631.30507-L01-v0.1-20220401.docx

Response to Request for Information 42 Honeysuckle Drive Newcastle NSW 2300

Thank you for your letter which requested further information (RFI) related to the Modification Application (Mod) for SSD 10378 Mod 2 located at 42 Honeysuckle Drive, Newcastle NSW 2300.

South Elevation

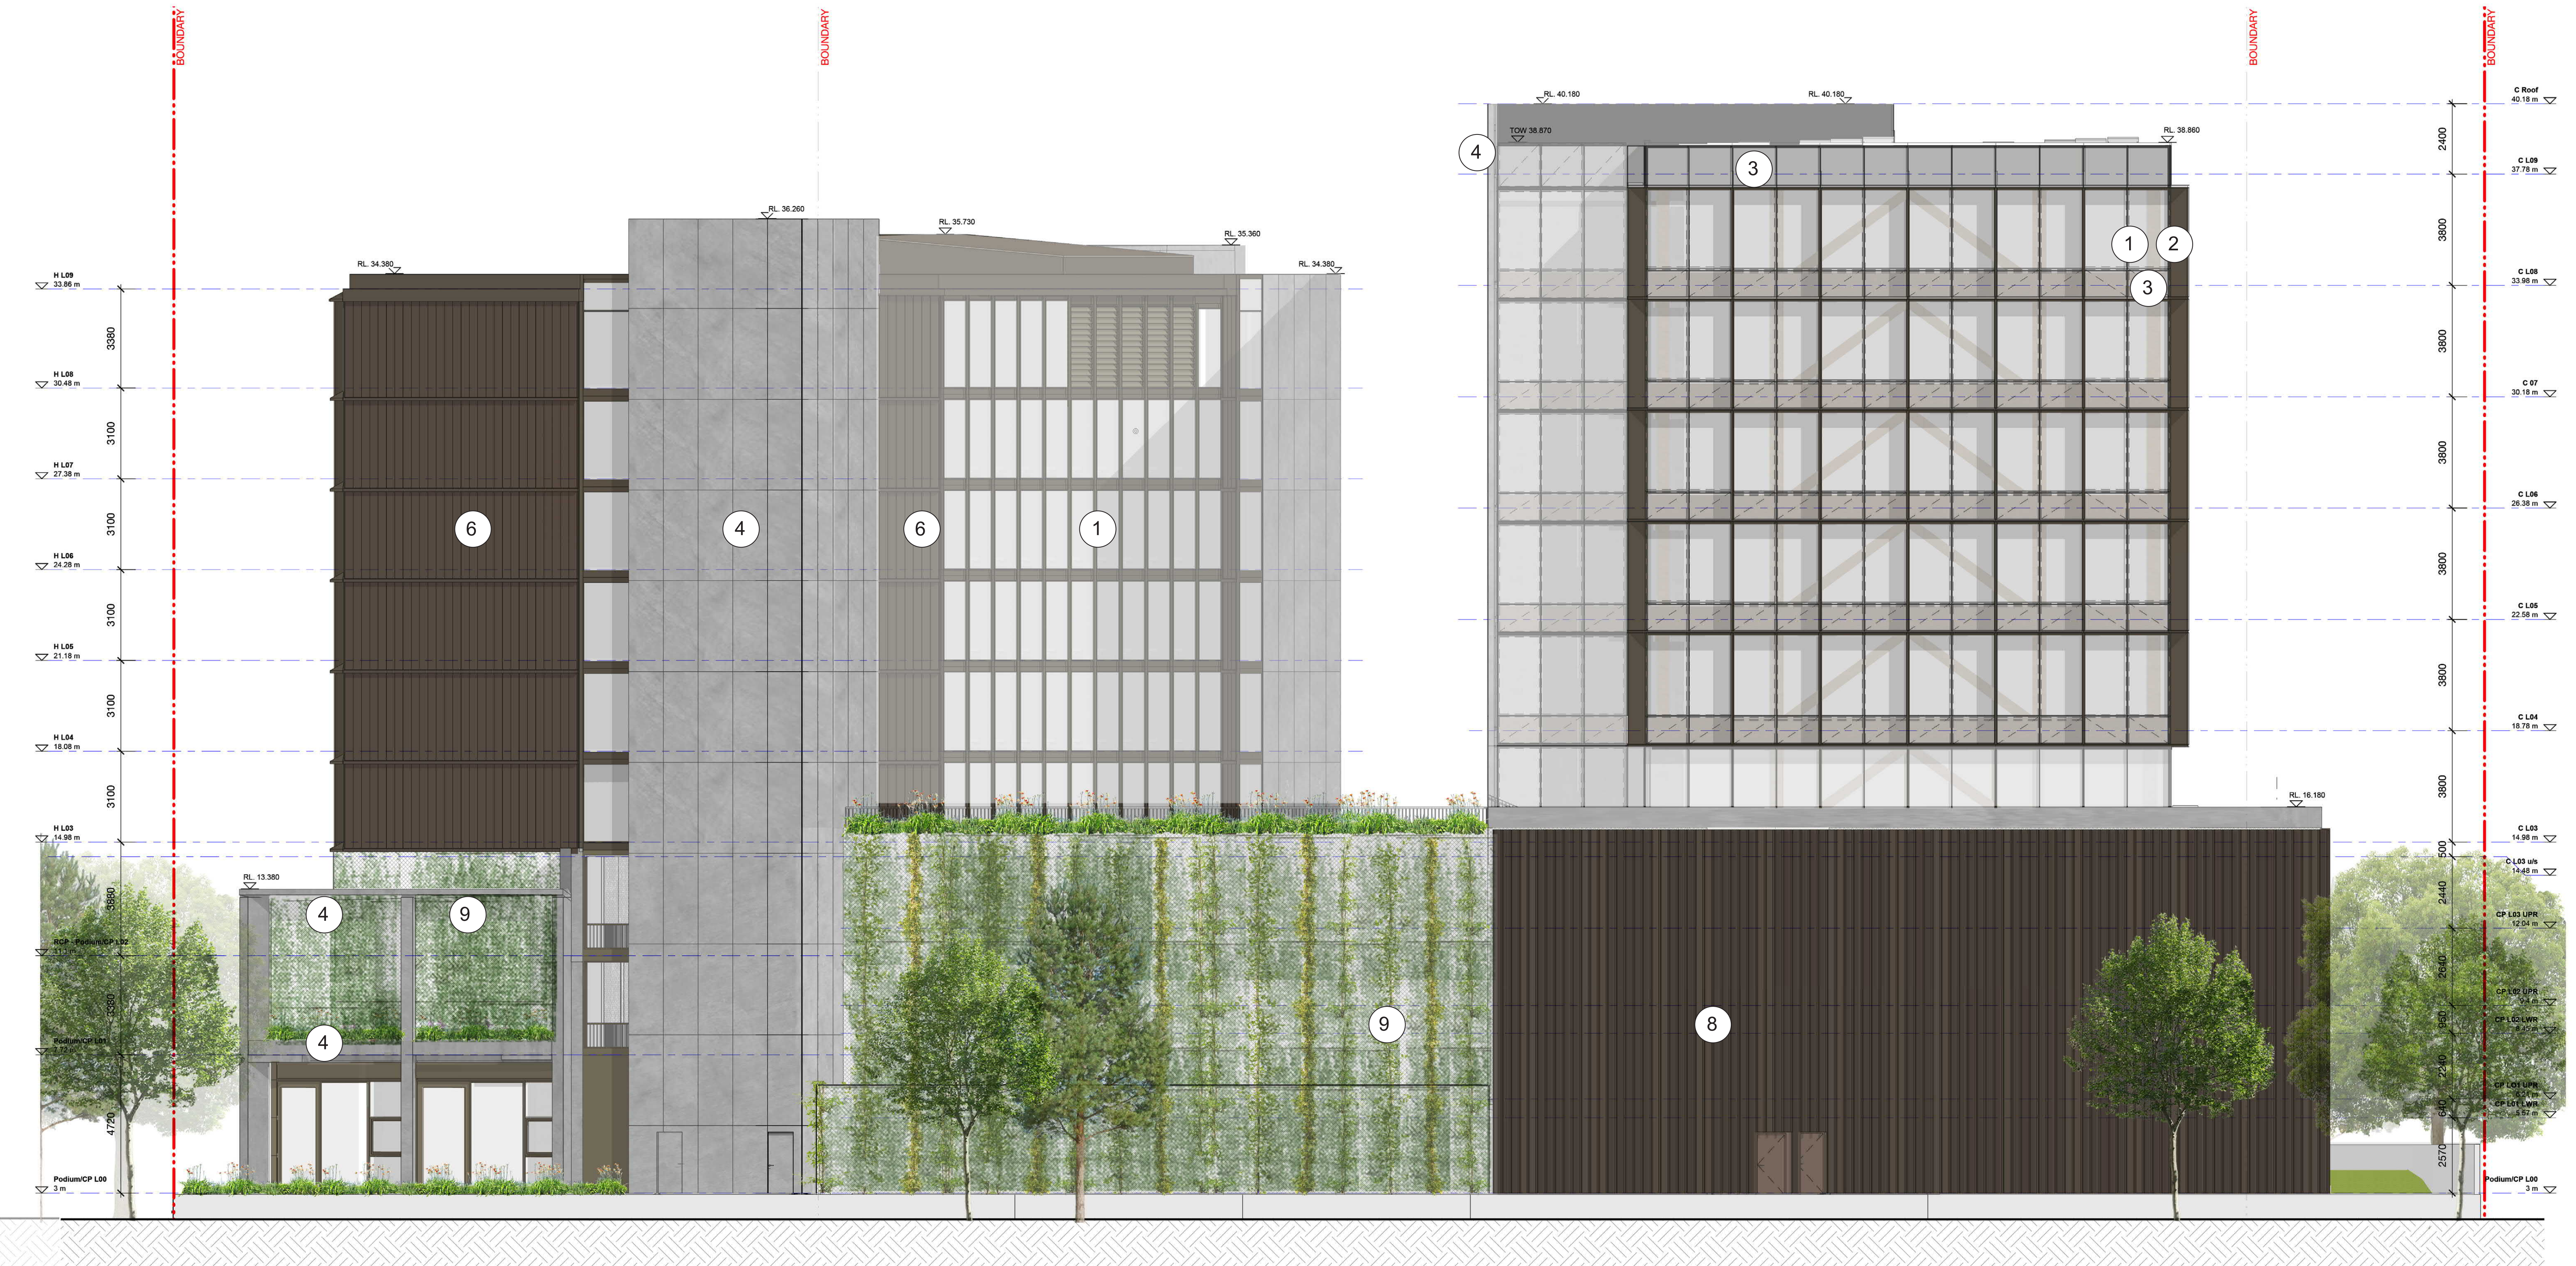
The proposed modification includes the provision of water tanks in the southwestern corner of the site. It is recommended clarification is sought from the applicant as to the reasons for the installation of the tanks in this location and whether the tanks will be used for the management of stormwater (including reuse) and therefore changes to the design of the approved stormwater plan are required. If changes are required, it is recommended the applicant is required to submit a modified stormwater plan.

The water tanks in the southwestern corner are for essential fire services and on site storage requirements for the fire sprinkler and hydrant system.

Their location is adjacent the fire hydrant booster room for compliance to be achieved. No updates to the stormwater management plan are proposed at this time.

1 Section AA 1 : 200

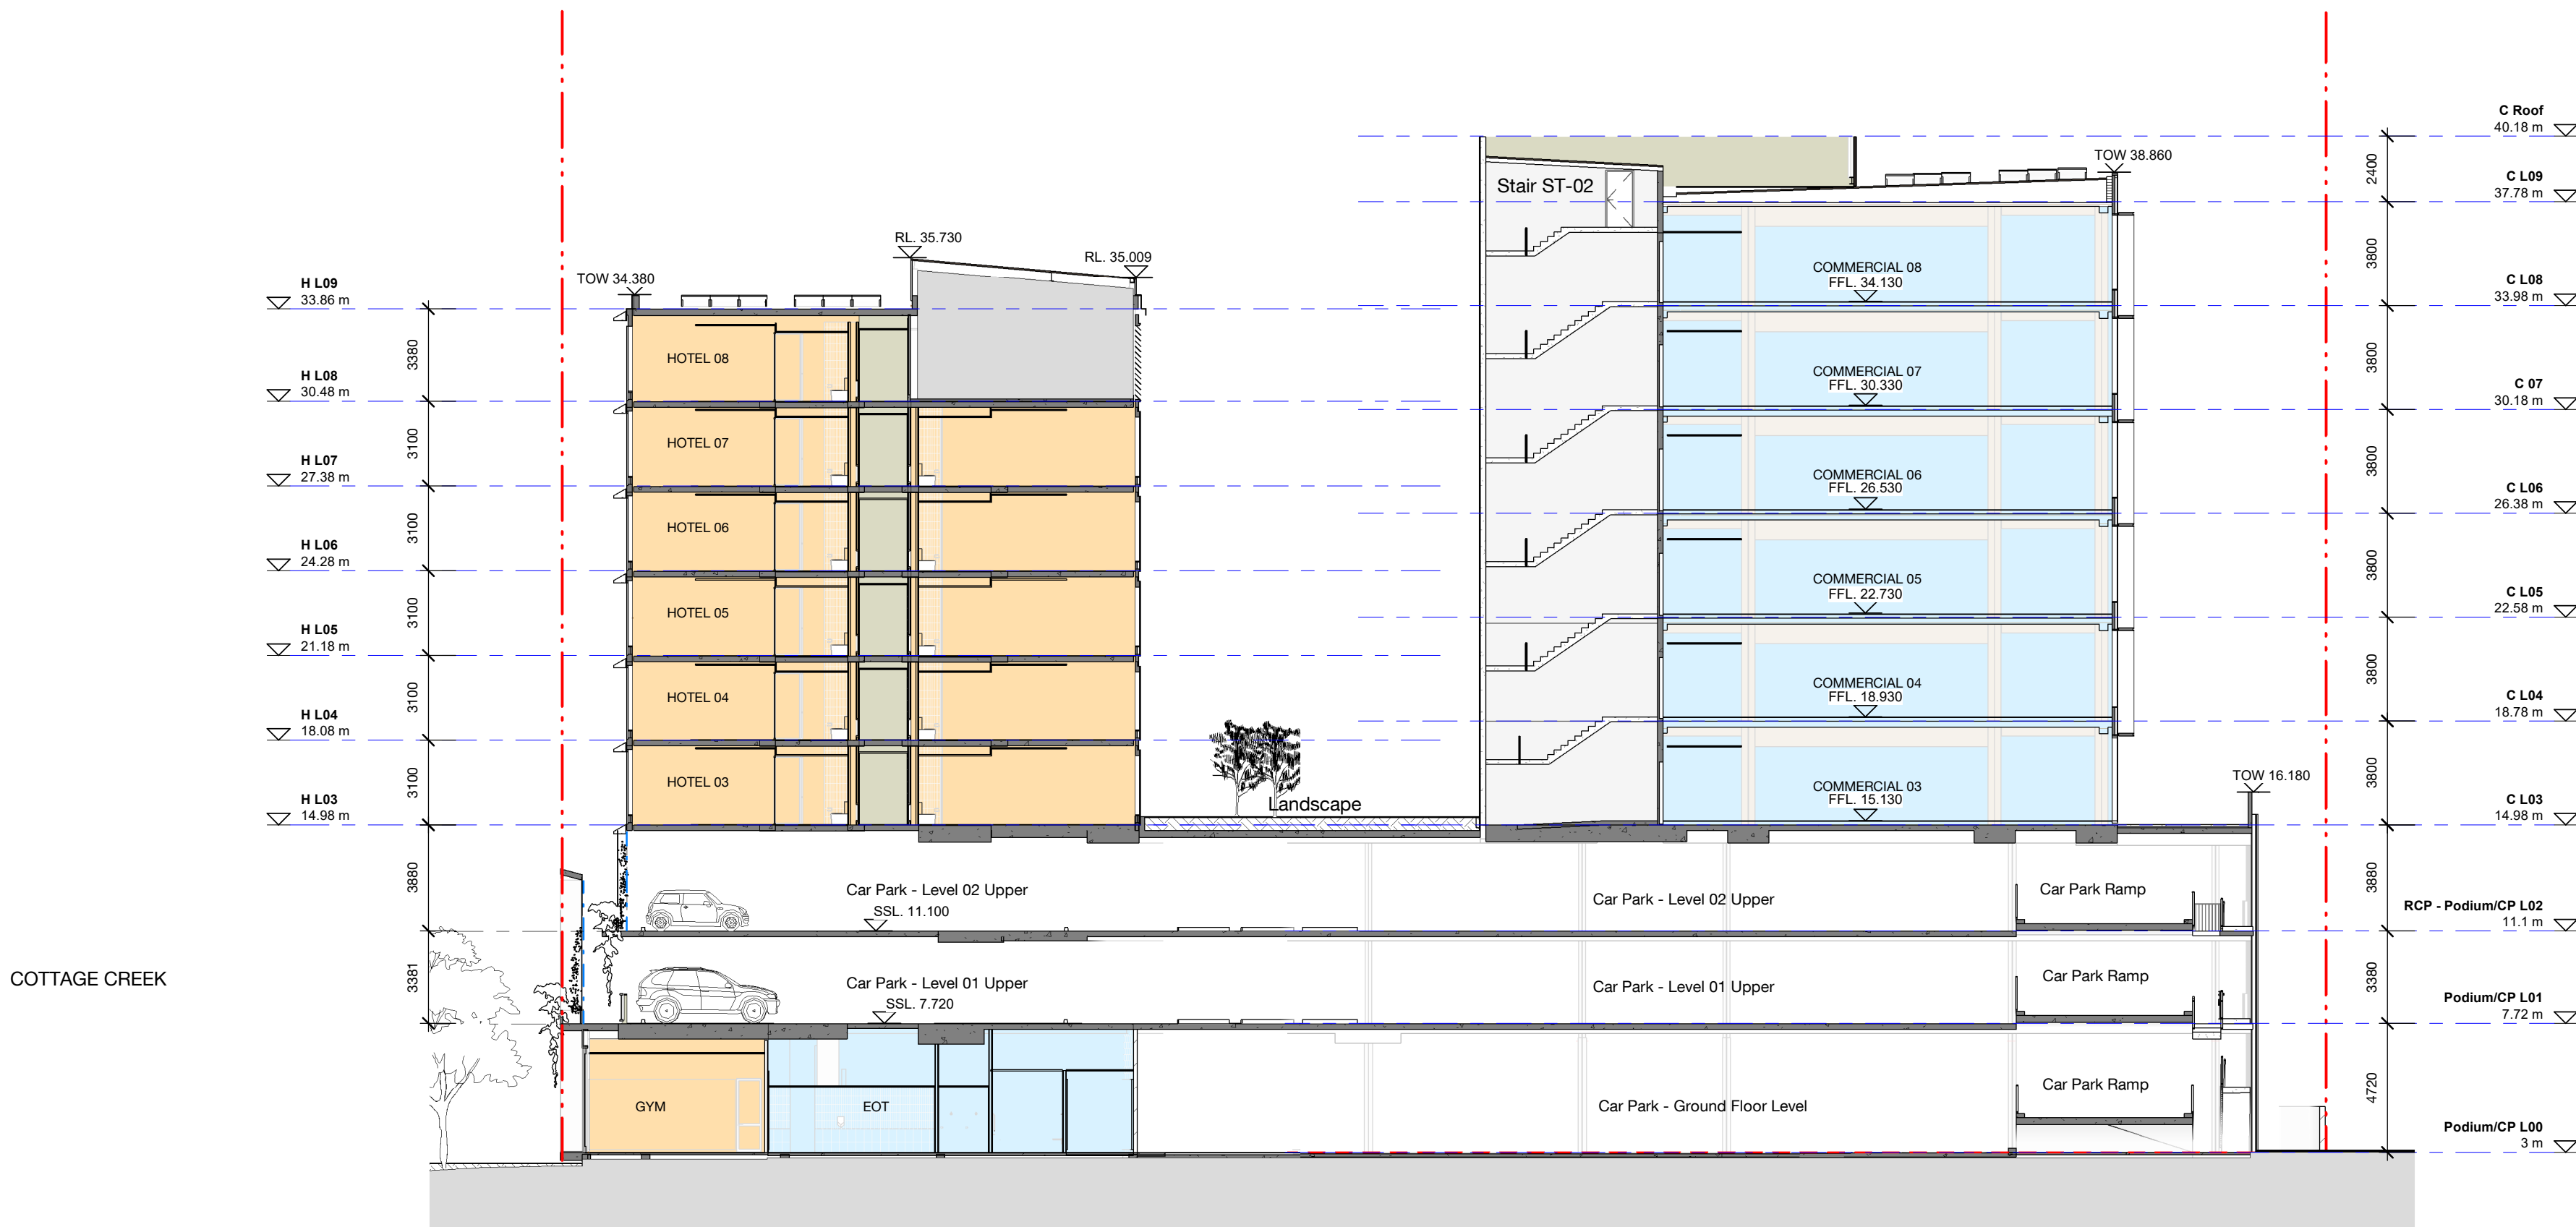
No acknowledgment and explanation are provided in the submitted documentation regarding the deletion of the section plans from Condition A2 of the development consent. It is recommended the applicant is required to provide modified section plans in support of the modification application.

Section plans have been provided as part of the Architectural Plans at Enclosure A.
